**NELSON GEOTECHNICAL
ASSOCIATES, INC.**
GEOTECHNICAL ENGINEERS & GEOLOGISTS

MEMORANDUM

RE: Pazarena Residence Addition
8430 SE 47th Place
Mercer Island, Washington
NGA File No. 996317

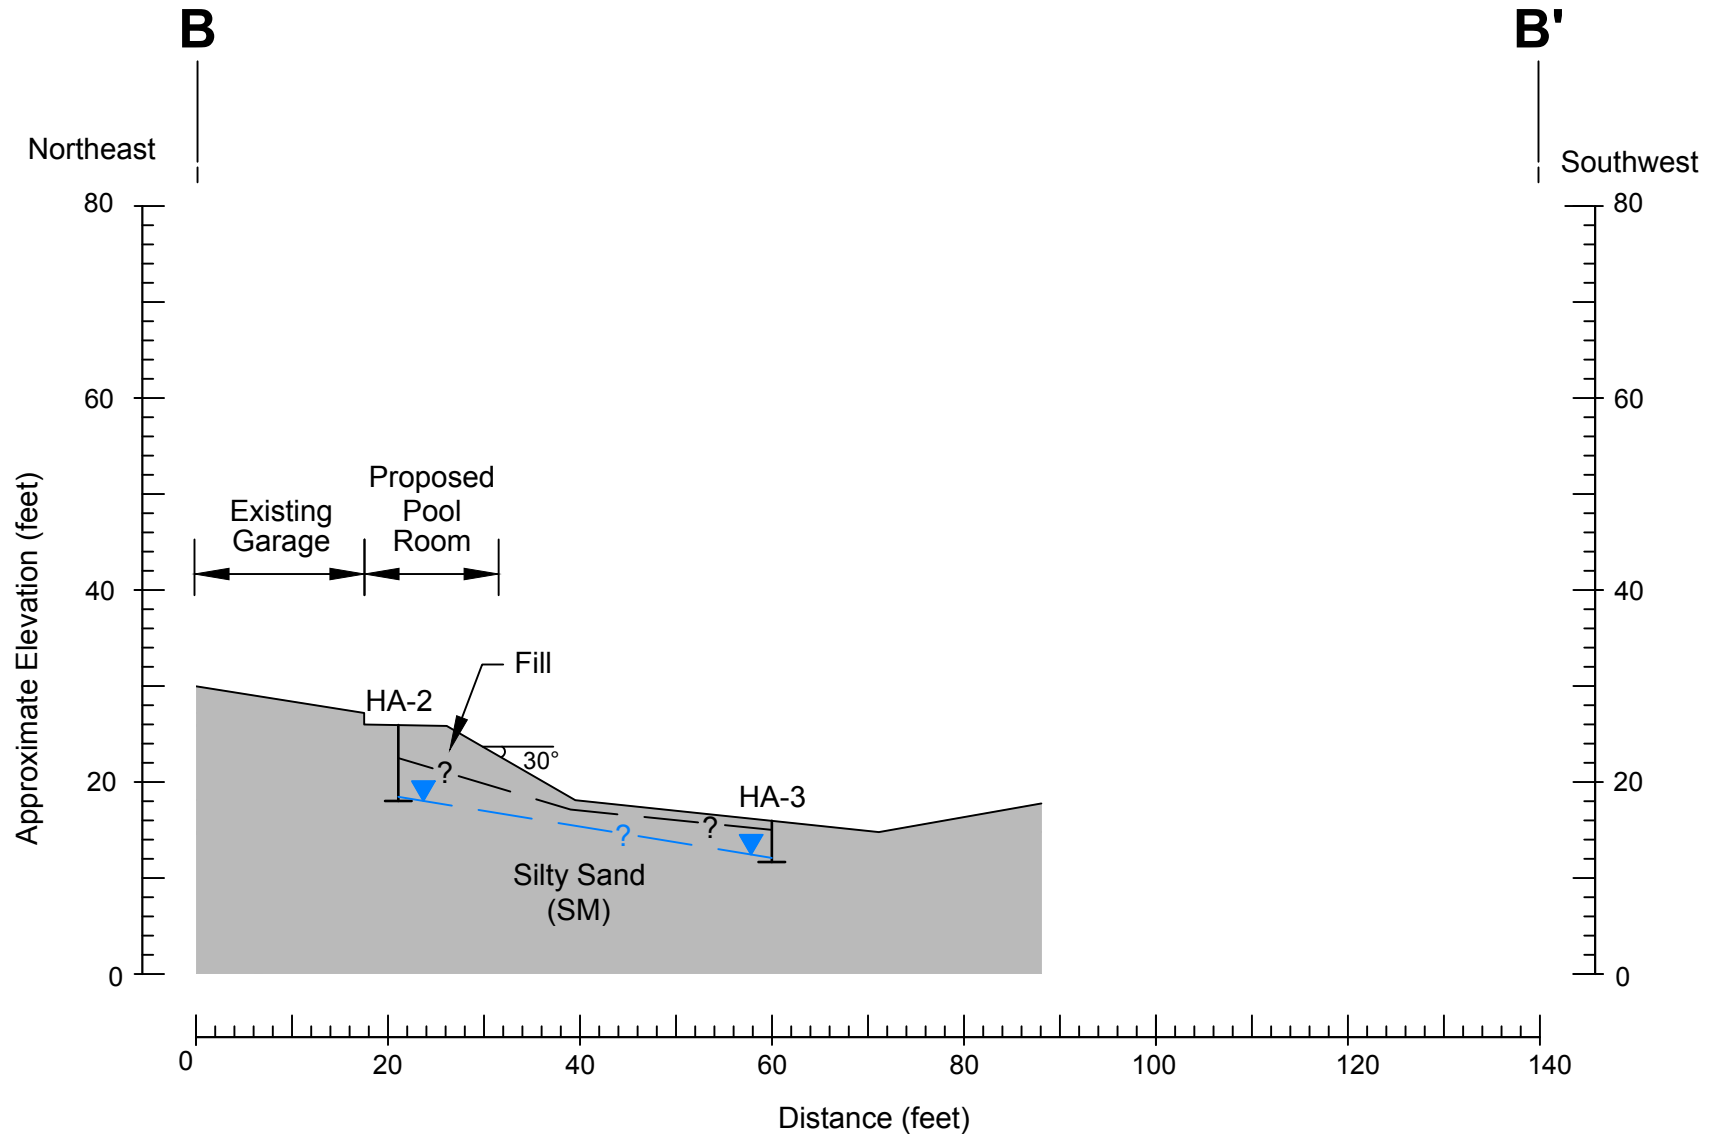
1. The Geotech report states that the addition will be constructed on a short, steep slope of 30 degrees, which is 58%. The definition of steep slope states that a steep slope is “Any slope of 40% or greater calculated by measuring the vertical rise of any 30-foot horizontal run.” Please provide the run of the slope that the Geotech refers to as steep, so the city can determine if there is a slope on-site that meets the definition of a steep slope.

Upon review of the geotechnical documentation, the slope in question is documented on Cross Section B-B’ in Figure 4 of the geotechnical report. It is located to the southeast of the existing garage. Semantically, the slope does not meet the definition the city is using for steep slopes. Over a 30-foot run, the slope in question [vertical rise of 10-11 feet] is at most 20° (36%), which is less than the 40% criterion. Furthermore, slopes to the southwest of the proposed garage [vertical rise of 8 feet] have a 30-foot run gradient of less than 15° (27%).

Geotechnically, the recommendations for the increased depth of foundations should remain since the new pool room is proposed to be constructed out on to this short slope, and foundations should be designed around localized topography. However, the slopes do not meet the technical classification of steep slope critical areas by the City of Mercer Island.
